June 21, 2024

Re: QuikTrip Store #7001- 521 Unser Blvd NW
Traffic Impact Study (K10D071)
Engineer's Stamp DRAFT
Via email jkruse@lee-eng.com

The subject Traffic Impact Study (Study) draft received on June 4th, 2024, has been reviewed by the City of Albuquerque Planning Development Transportation Section. The City has the following comments to be addressed.

SHEET TITLE:
SITE PLAN

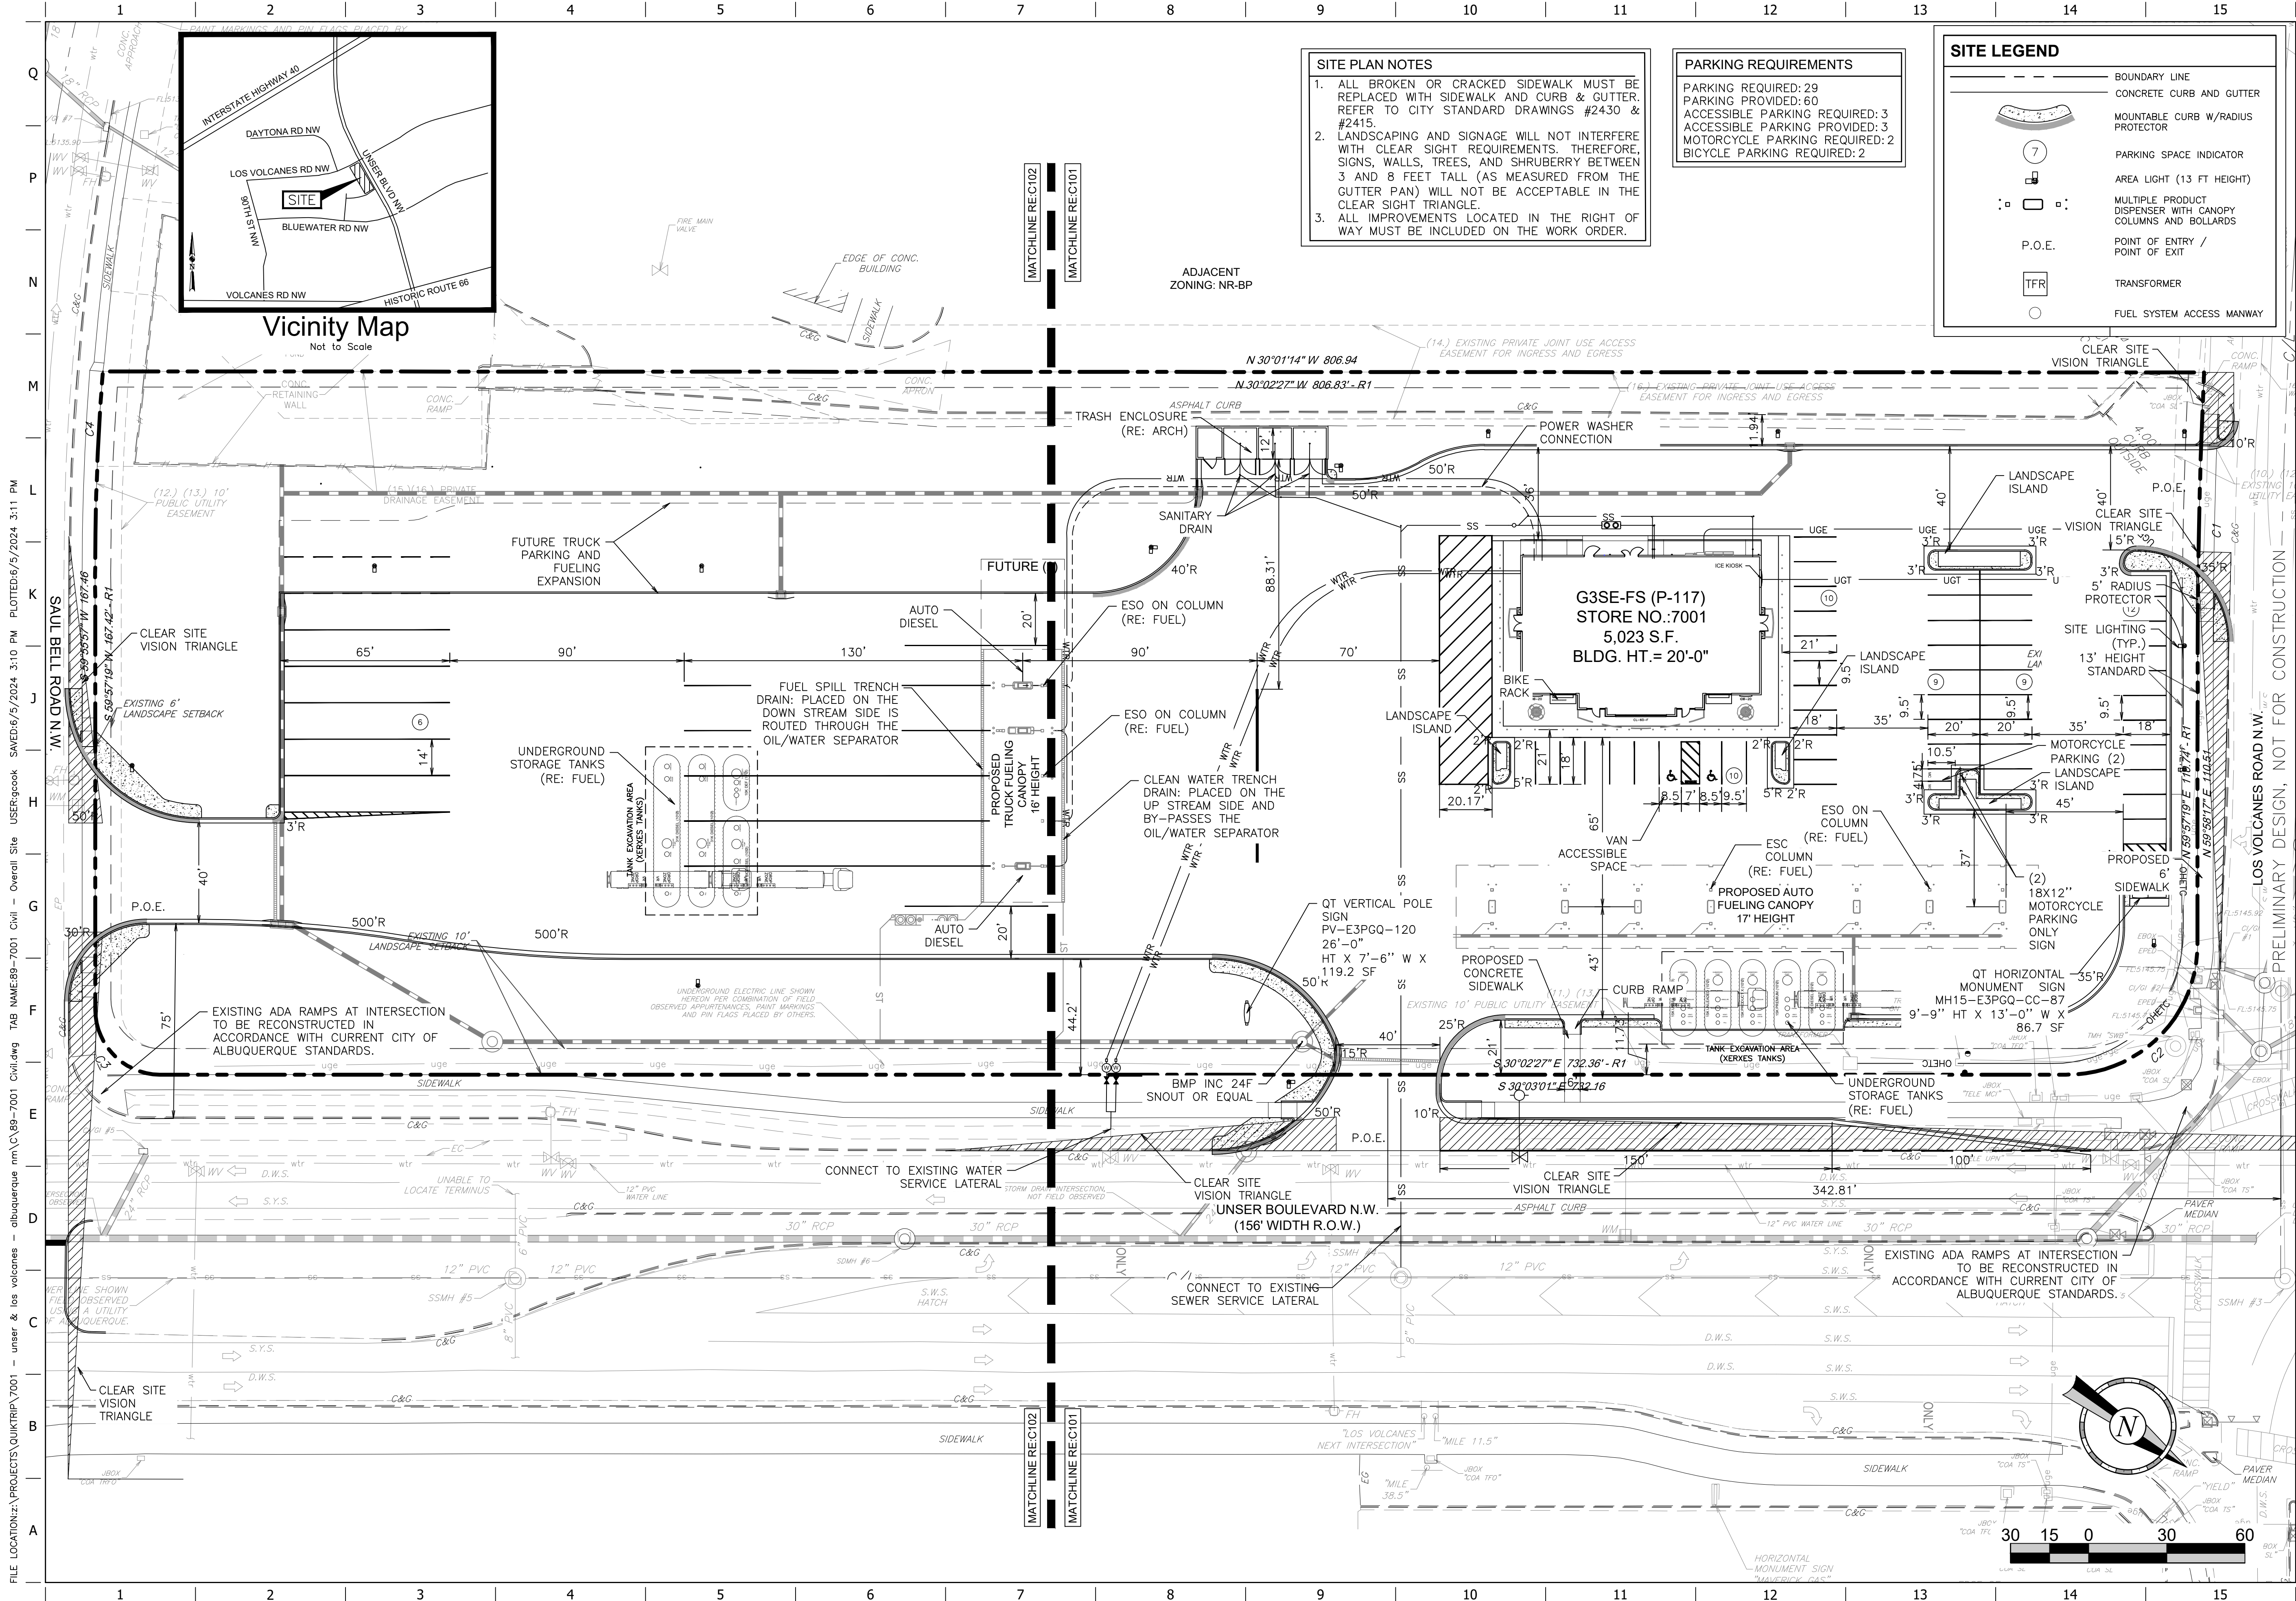
1. Unser Blvd is a Limited Access Roadway and therefore the driveway on Unser Blvd, Driveway 2, is not allowed.
2. Site access is to be provided via two driveways: one on Los Volcanes Rd and the other on Saul Bell Rd.

3. The driveway on Saul Bell Rd is to be located a minimum of 200 feet from Unser Blvd. It appears the west property line is approximately 285' from Unser Blvd. I am aware of the distances in DPM Table 7.4.45, however, per the Site Plan it appears the tractor trailer entrance is off of Saul Bell and the length of the tractor trailer combined with the reduced speed of leaving the roadway, queuing onto Unser Blvd may occur and should be prevented.

4. Provide a cleaner image of Figure 1: Site Plan. Please include dimensions from the driveway(s) to Unser Blvd.
5. On p. 10; the Study Intersections shown on Figure 2 don't match the listing in the paragraph below the Figure.
